DEPARTMENT OF PUBLIC WORKS

MEMORANDUM

TO: Community Development Services
FROM: Public Works Planning Review Team
DATE: February 2, 2021
SUBJECT: SPF-21-00001 Riste

RISTE SHORT PLAT SP-15-00007

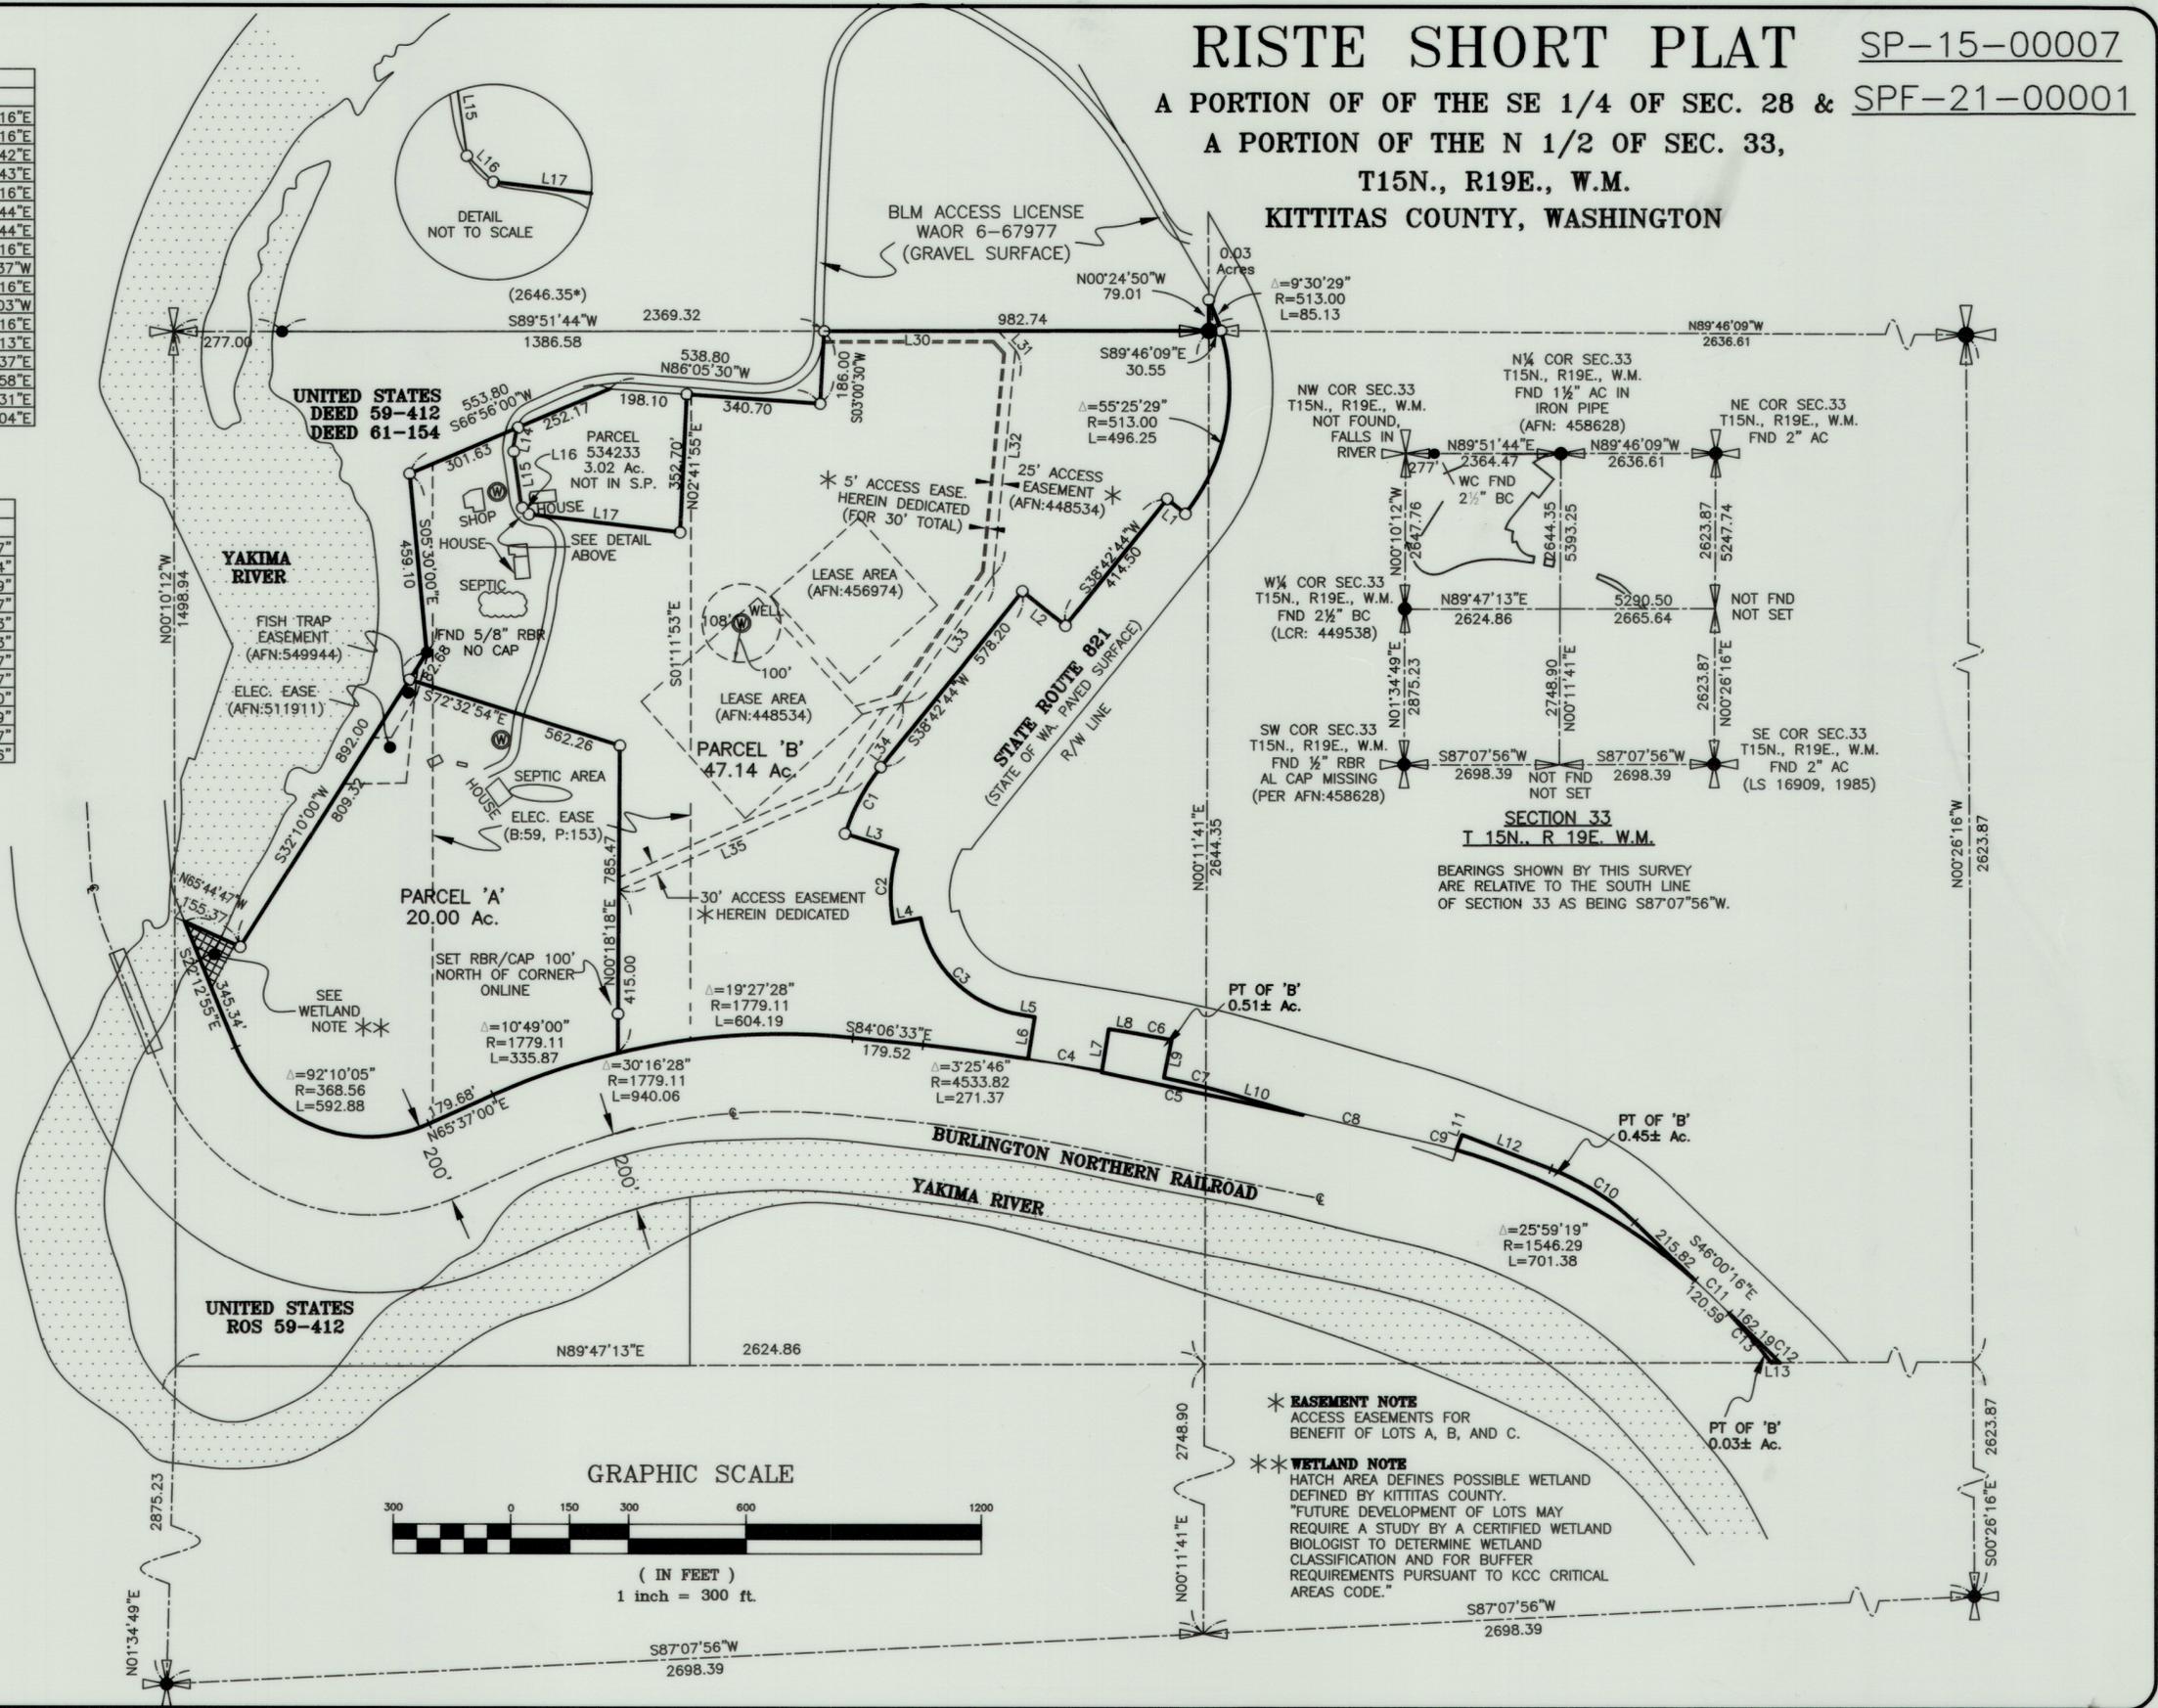
C-1 "Metering is required for all new uses of domestic water for residential well connections and usage must be recorded in a manner consistent with Kittitas County Code Chapter 13.35.027 and Ecology regulations."

C-2 "The approval of this division of land provides no guarantee that use of water under the ground water exemption (RCW 90.44.050) for this plat or any portion thereof will not be subject to curtailment by the Department of Ecology or a court of law."

# RISTE SHORT PLAT SP-15-00007

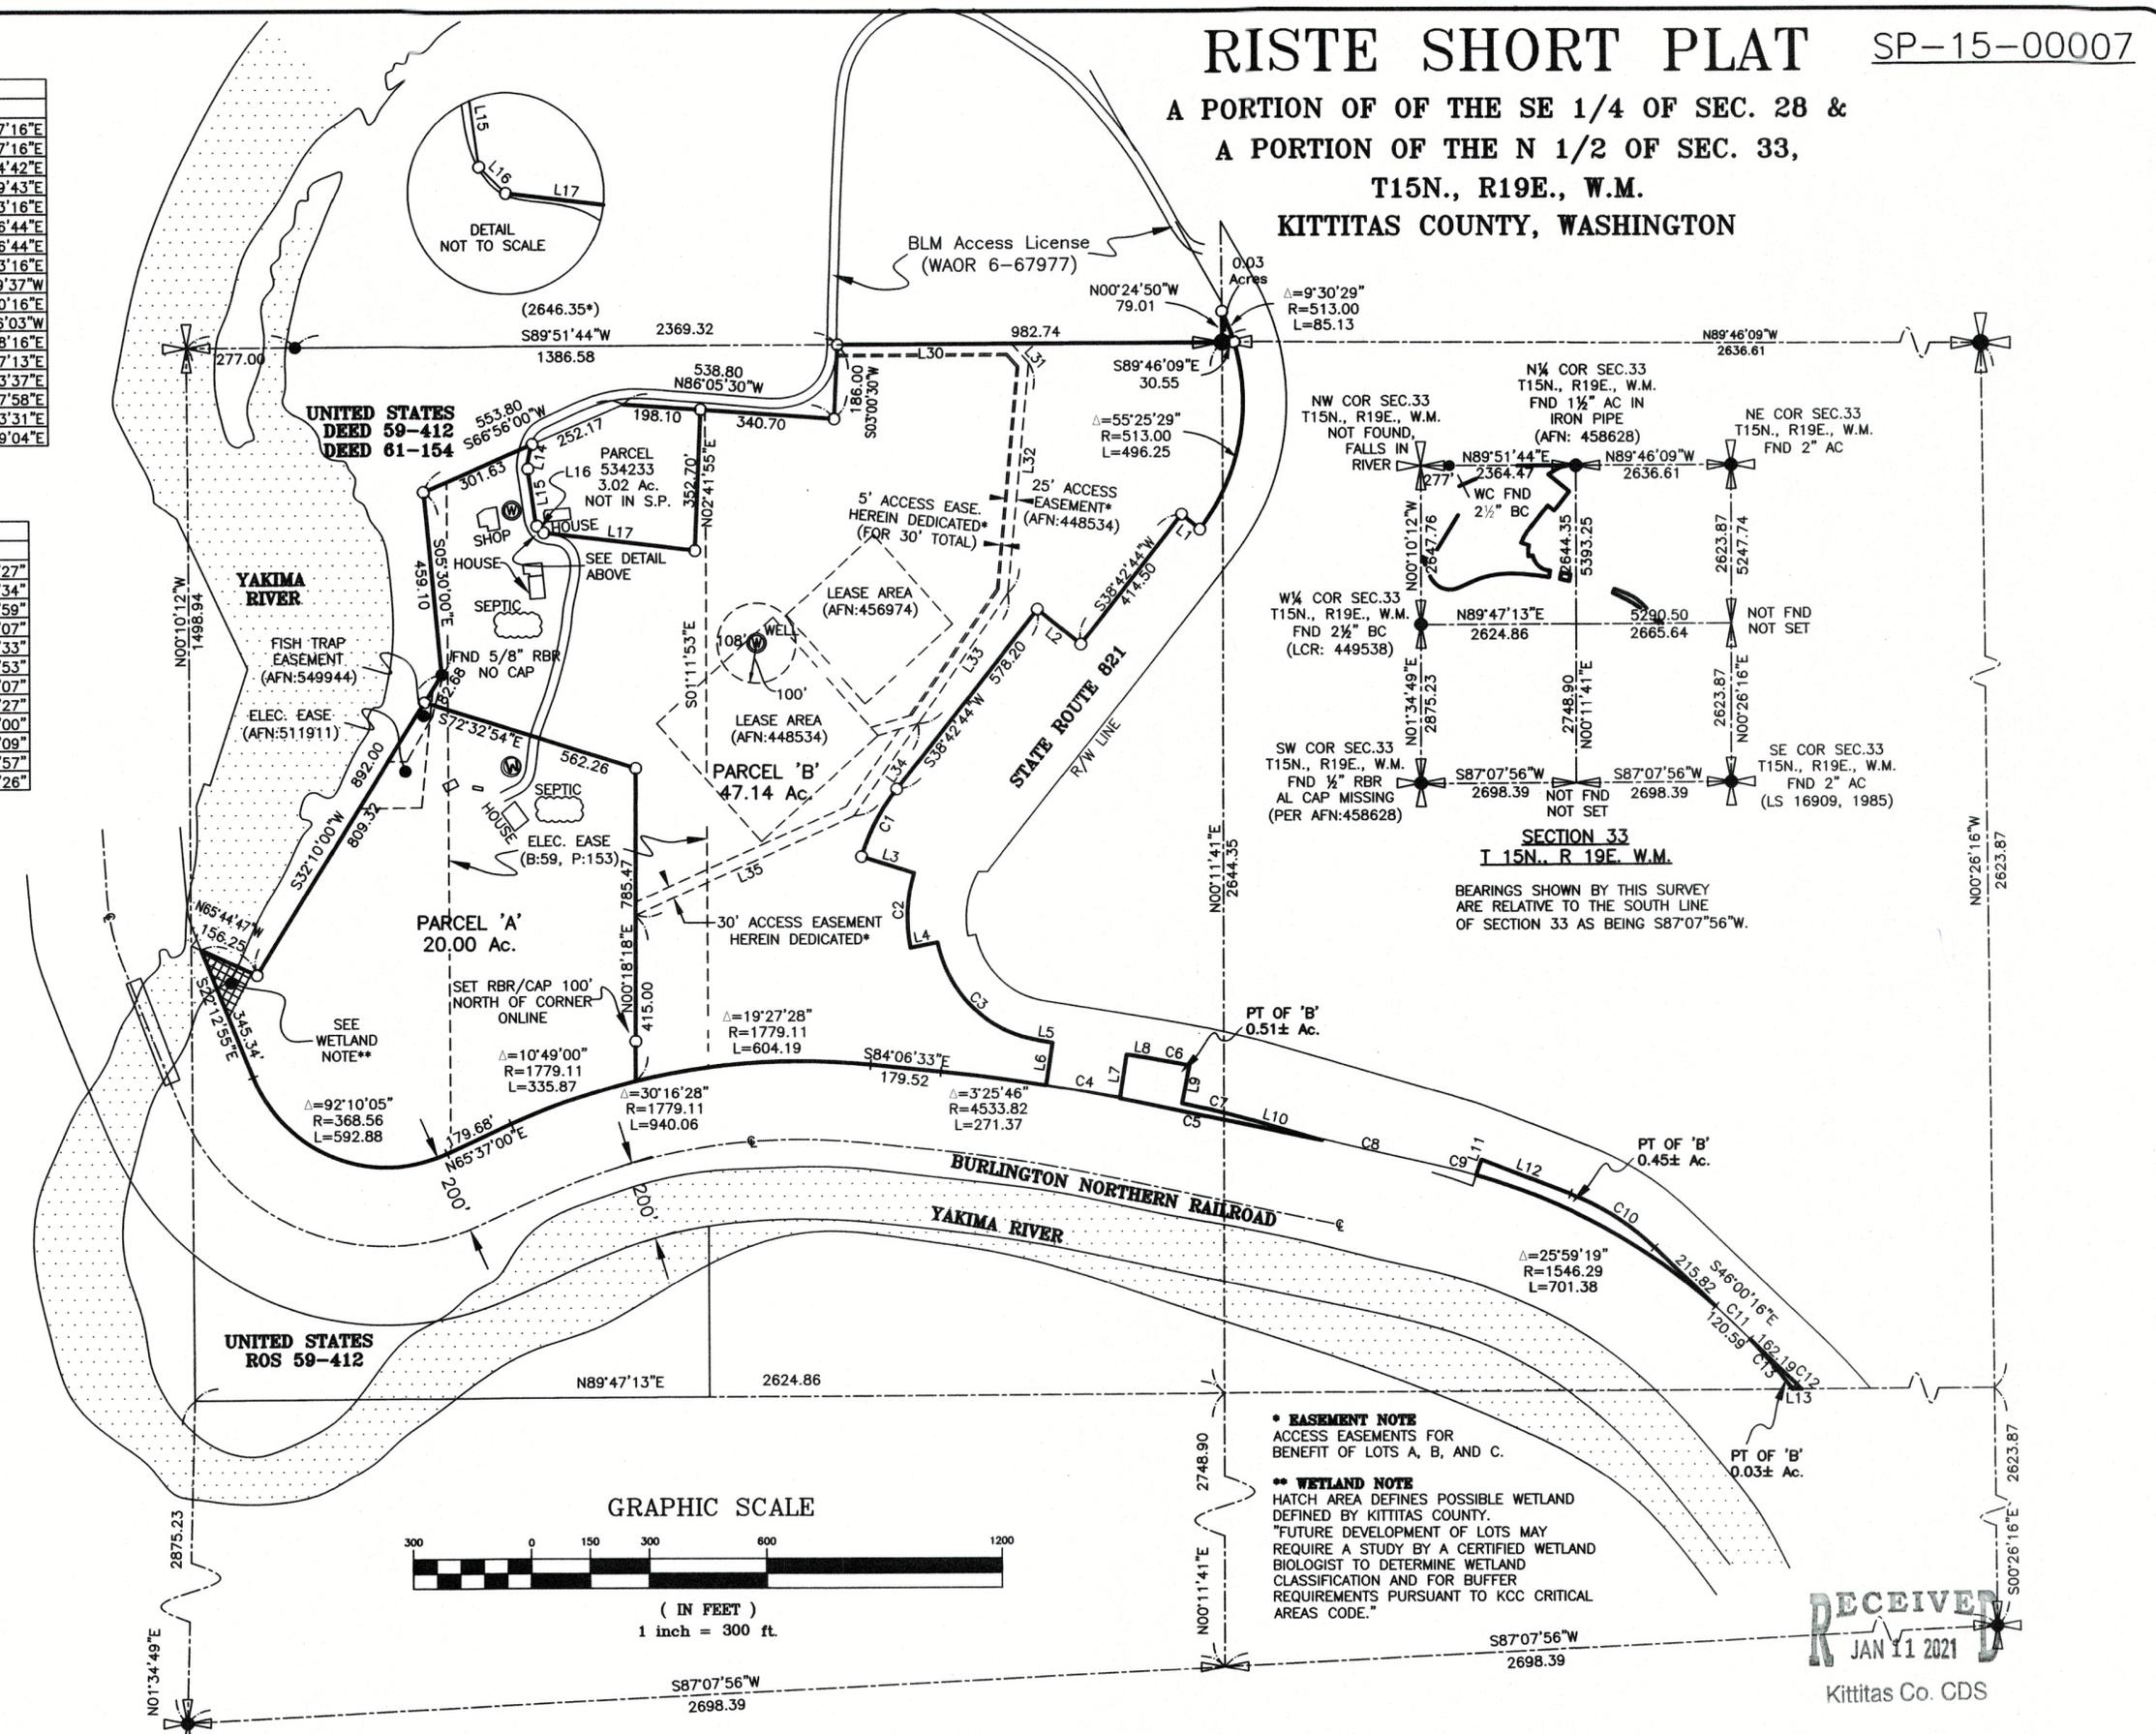
1. North line of wetland area on Lot A disagrees with closure report 156.25 vs 155.37.
2. The north line of Parcel 534233 are 2 different line types (thick and thin) – Not a required change.
3. All Roadways must show name, width, underlying ownership (Private/County/State), easement or right of way, and surfacing material.
